CITY OF ALBUQUERQUE

June 21, 2017

**RE: Glendesto Subdivision
Grading Plan and Drainage Report
Engineers Stamp Date: 6/15/17
Hydrology File: B18D020**

Based on the information provided in your submittal received on 6/16/17, the Grading Plan and Drainage Report are not approved for Grading Permit or Preliminary Plat. The following comments must be addressed prior to approval:

SEE SHEET 2 FOR OFF-SITE
GRADING & DRAINAGE

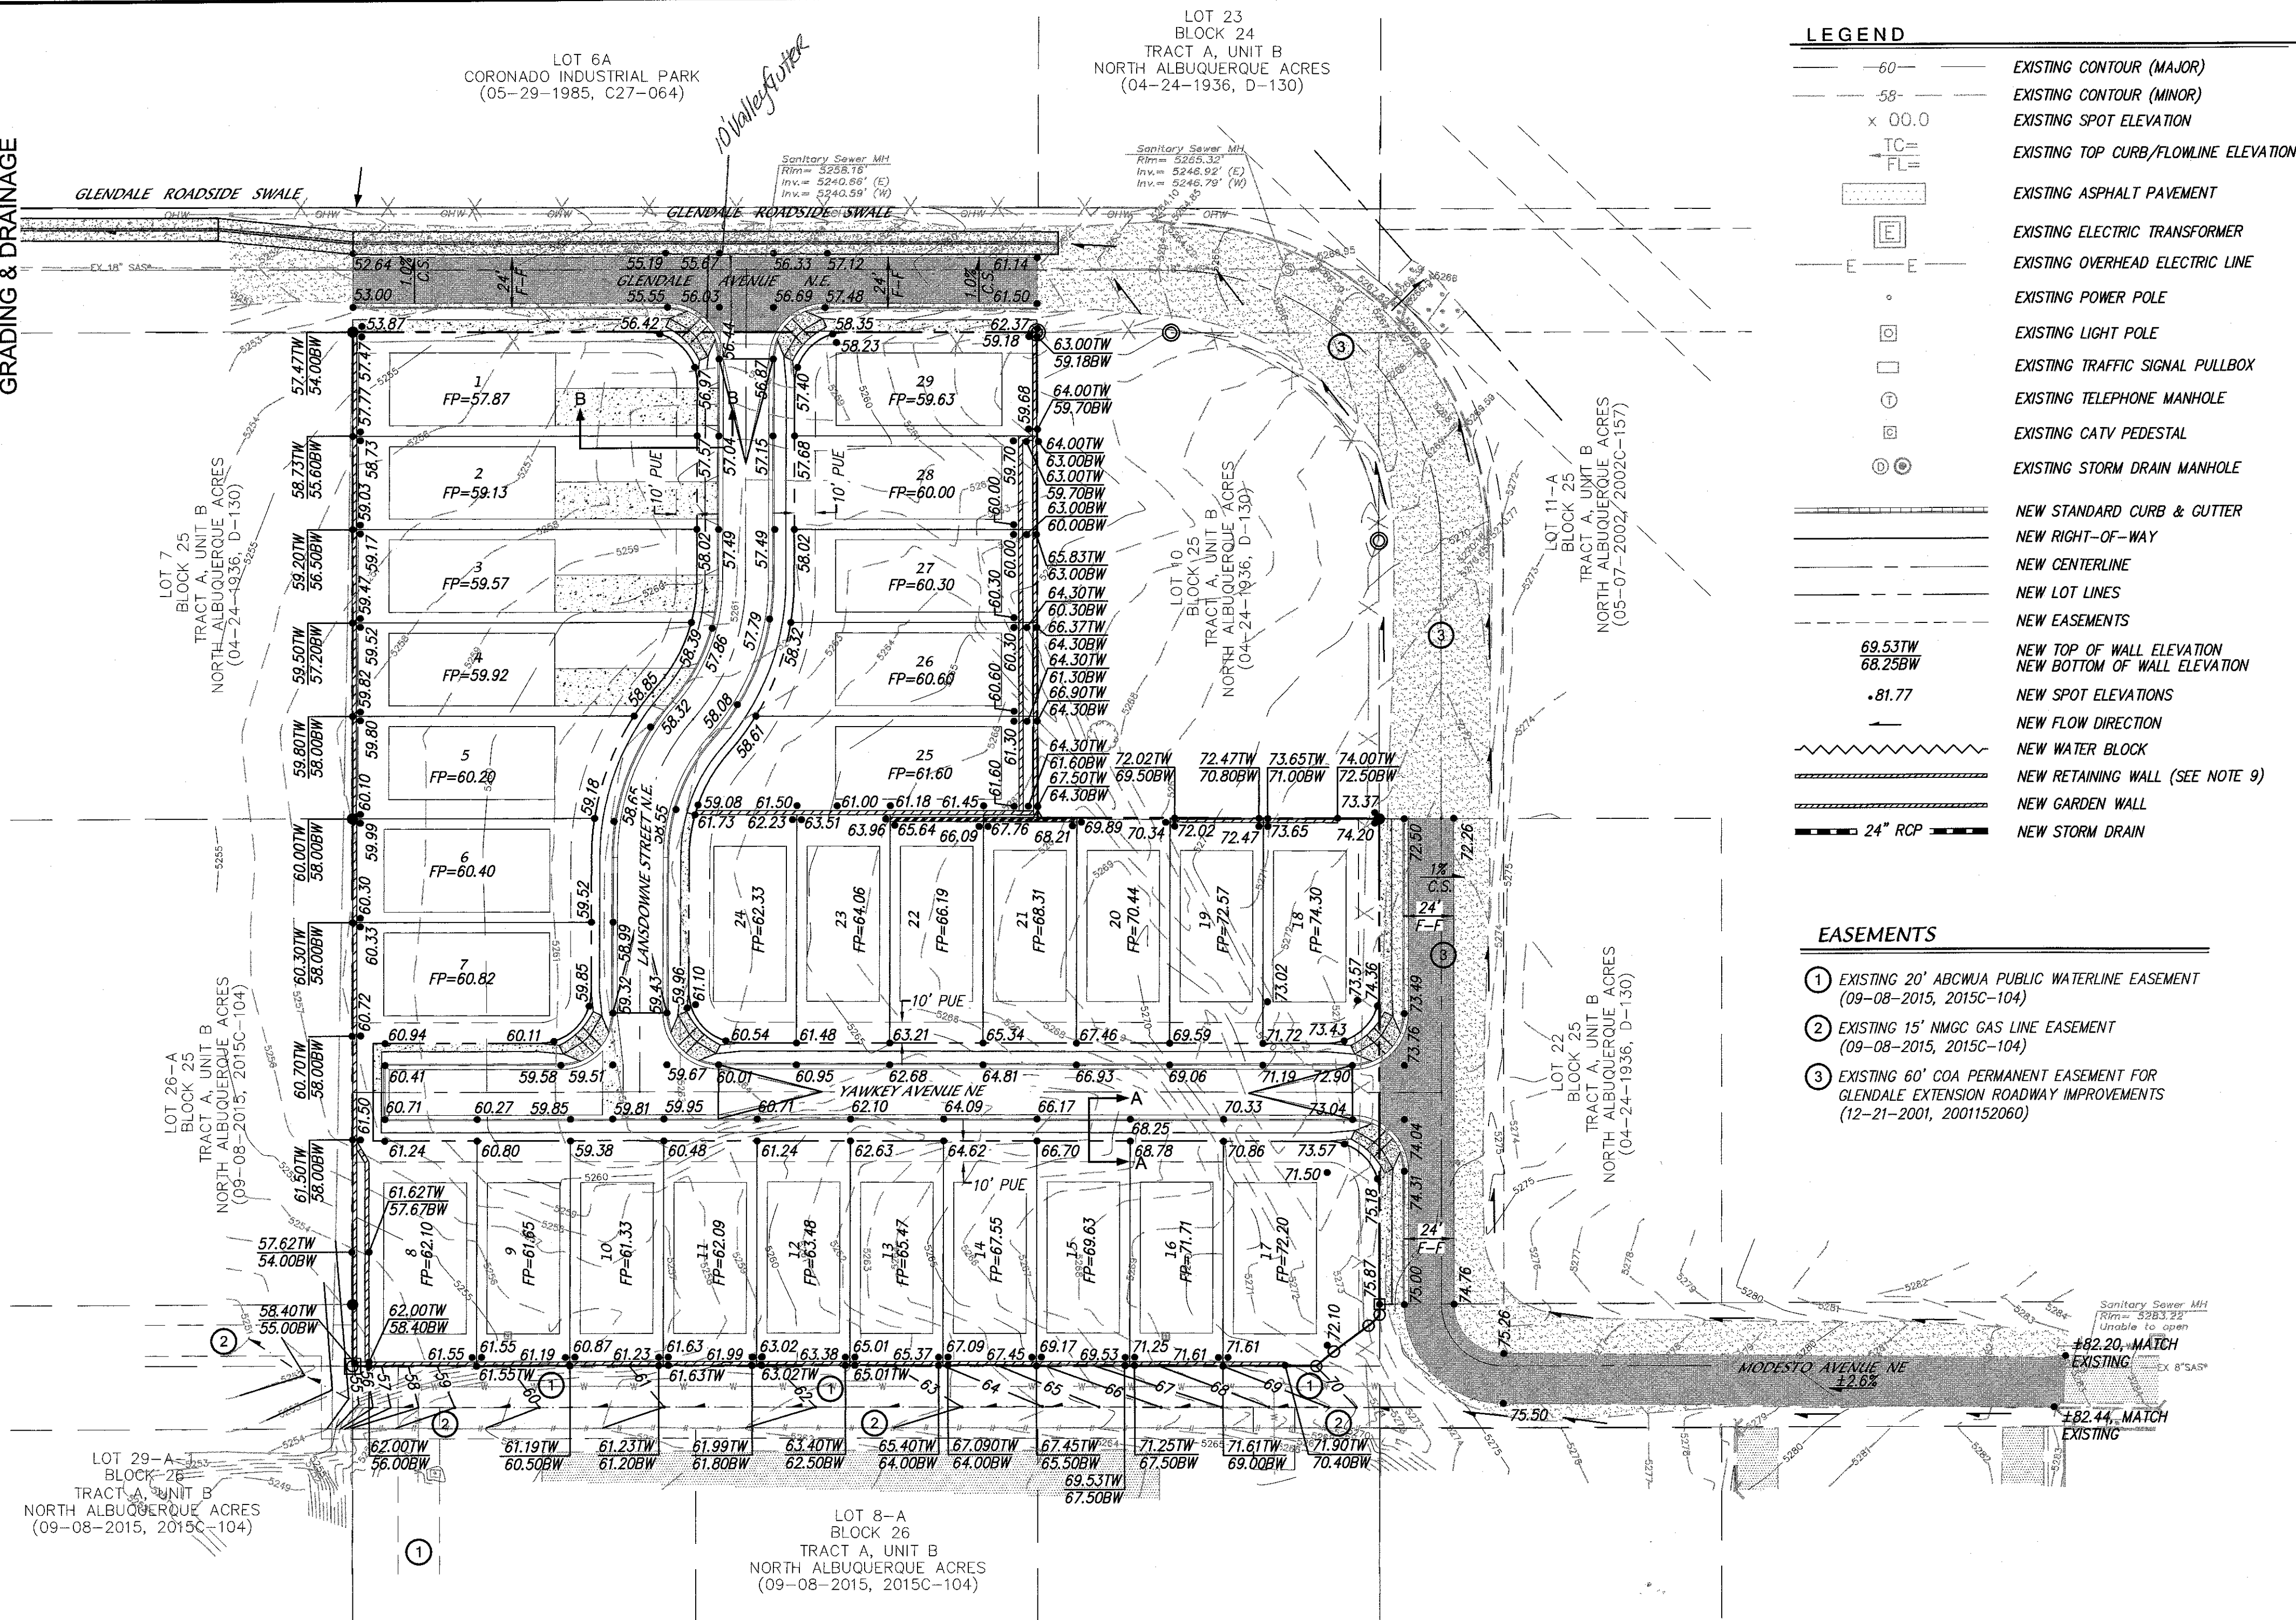
1. The proposed channel on Tract A needs to be designed to accommodate 1.0' freeboard according to Ch. 22 of the DPM. Also the channel top width in the drainage report is 9' wide, but the top width shown on the grading plan is only 5' wide.

2. What happens where the Tract A channel crosses the sidewalks on Glendale and at the hammerhead? It seems like arrays of sidewalk culverts need to be sized and designed here and included on the Infrastructure List.

3. The Glendale roadside channel designed in the drainage report does not match the channel shown on the plans.
4. What happened to the double retaining wall along the west side of lot 23, formerly lot 8? The single retaining wall topped with a garden wall will exceed the 8' maximum and the double wall may infringe on the 5' setback for the pad.

5. Recheck the pad elevations. Many pads have enough elevation difference to require retaining walls in between lots such as: lot 21, and lot 24/25.
6. A revised ESC plan is required prior to Grading Permit approval.
